CITY OF PORTLAND, MAINE
PLANNING BOARD

February 12, 2008

RE: The Estates at Longfellow Inn. 130 Eastern Promenade
Chart: 3 **Block:** C **Lots:** 1 and 2
Application ID: 2007-0123

**THE ESTATES AT LONGFELLOW INN
130 EASTERN PROMENADE**

NOTE:  
REMOVE EXISTING NORWAY MAPLE.  
REPLACE WITH ARSTRONG MAPLE

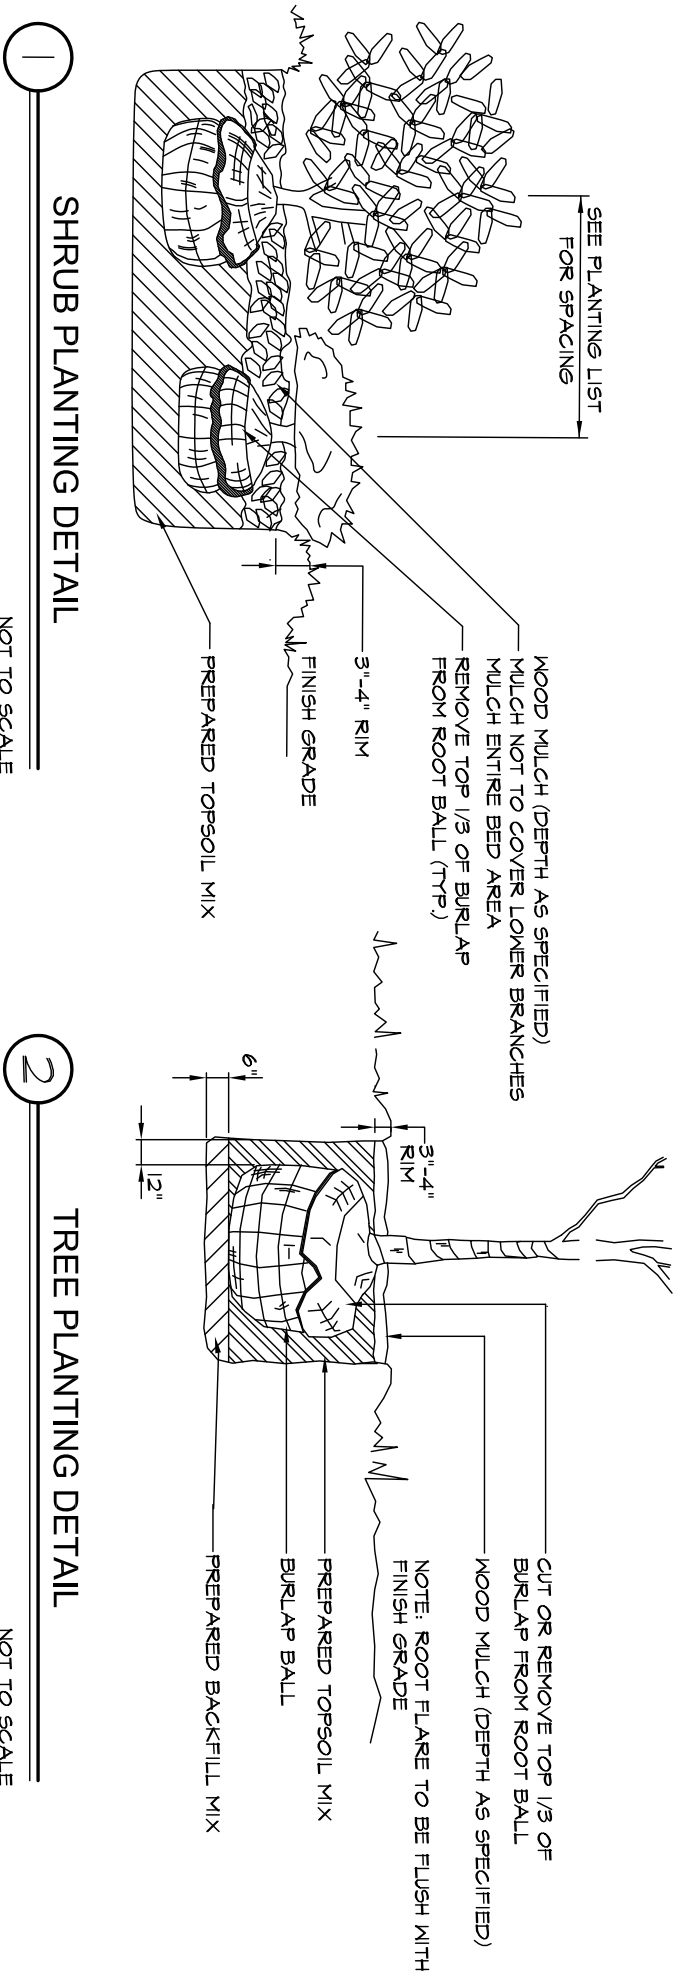
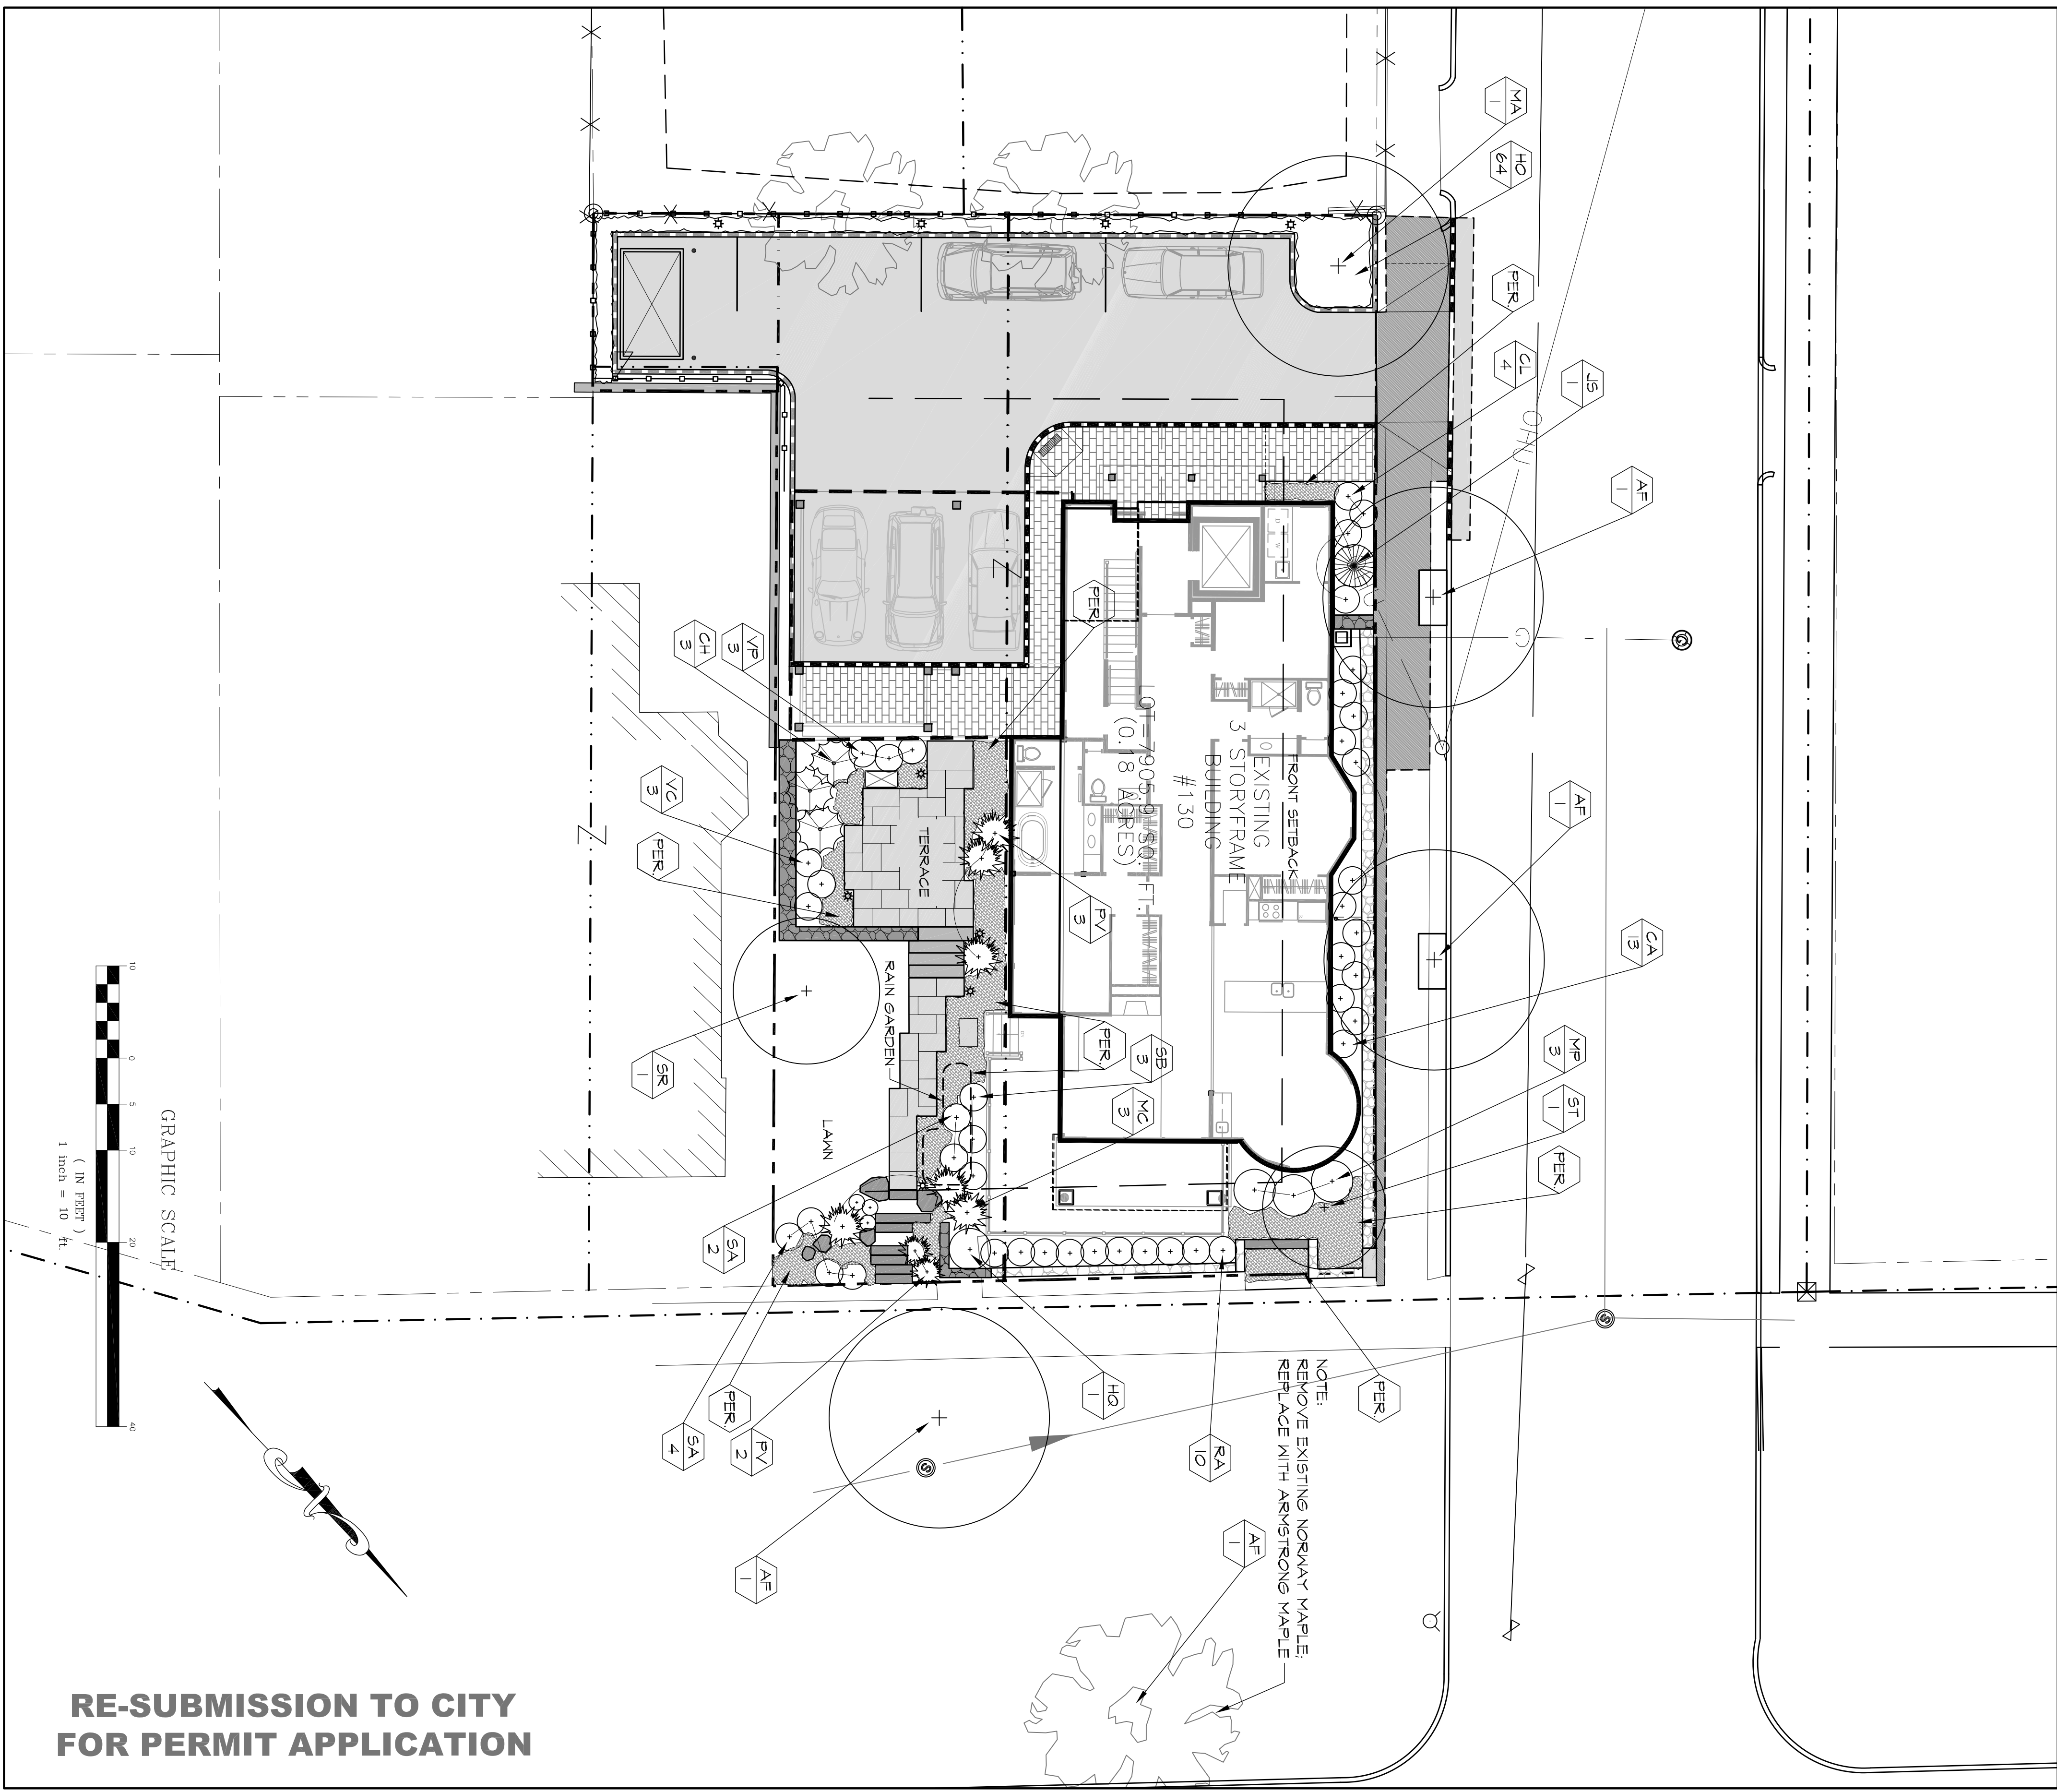
- v. The proposed street tree along the Eastern Promenade shall be revised to show an Autumn Blaze Maple (*Acer freemanii*). This change to the plans must be reviewed and approved by Jeff Tarling, City Arborist prior to the issuance of a building permit.
